TOWN AND COUNTRY PLANNING ACT 1990 FULL

Reference: H13-0058-25 **Date of Decision:** 16th April 2025
Applicant: Ms A Riley
Decoy Farm
Fen Gate
Moulton Chapel
Spalding
PE12 0XL
Location: Decoy Farm Fen Gate Moulton Chapel Spalding
Description: Conversion of existing stable block to 2 self contained units to provide assisted living accommodation

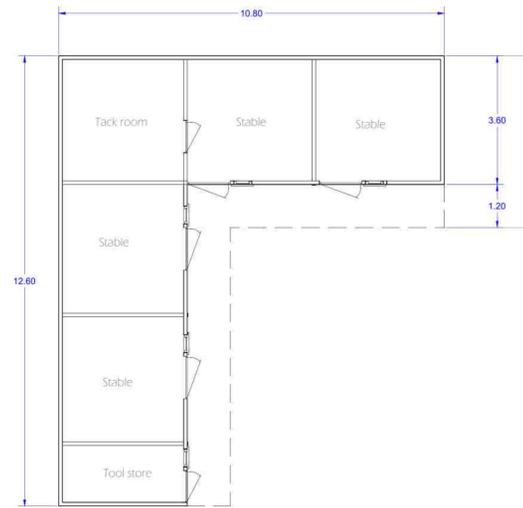
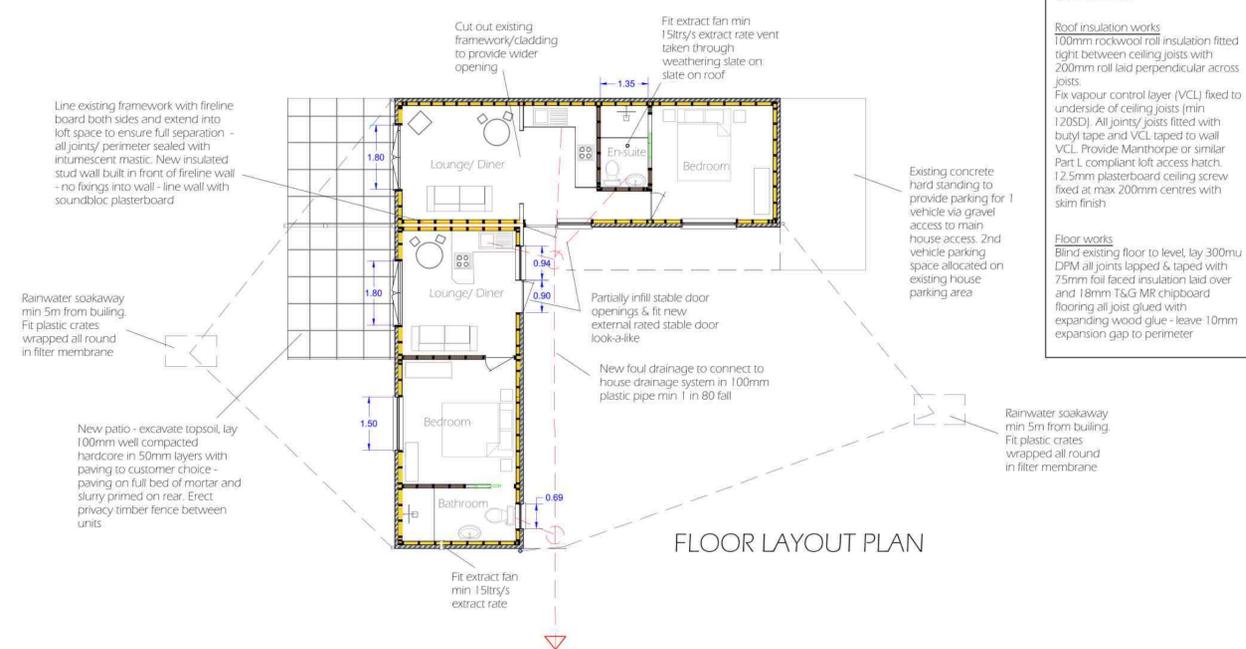
- 1 The proposed development does not provide sufficient internal living space as the development would not accord with the nationally described space standards. The proposed development would therefore not provide a high quality standard of living for future occupants.

As such, the proposed development conflicts with Policies 2 and 3 of the South East Lincolnshire Local Plan (2019), which seek to ensure that proposals have a suitable impact on the amenity of future occupants of proposals. The proposed development also conflicts with Paragraph 135 of the National Planning Policy Framework (December 2024), which seeks to ensure that development provides a high standard of amenity for existing and future users.

Decoy Farm Moulton Chapel

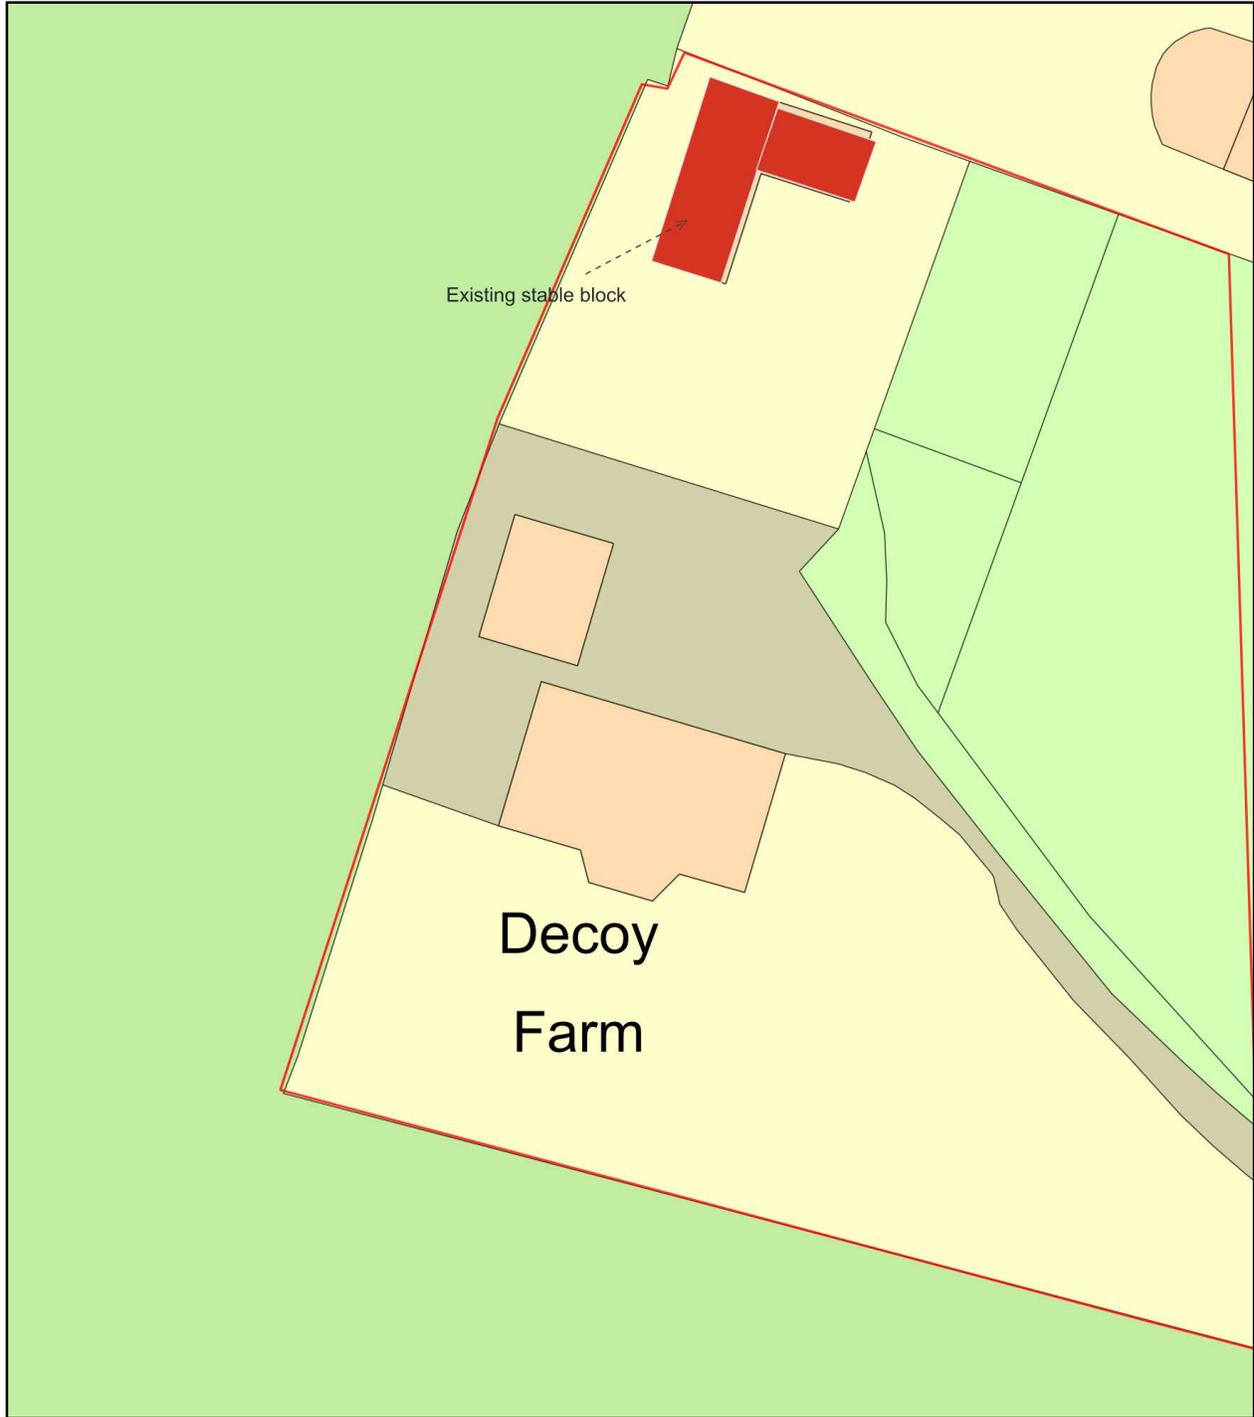
- 2 Lincolnshire Fire and Rescue Service have set out an objection to the proposed development as the proposal would not meet the requirements specific in Building Regulations 2010 (as amended) Part B. Building Regulations set out that there should be

vehicle access for a pump applicant to within 45m of all points within the dwelling house (Part B5, 11.2). It has not been demonstrated that a fire engine can access the site, turn and reach all points of the proposed dwellings. As such, the proposed development could pose a risk in terms of fire safety. The proposed development would therefore not accord with Policy 3 of the South East Lincolnshire Local Plan (2019), which requires proposals to demonstrate how community safety will be maintained (part 8). There is also considered to be a conflict with Paragraph 102 of the National Planning Policy Framework (December 2024) which requires planning decisions to promote public safety (part a).
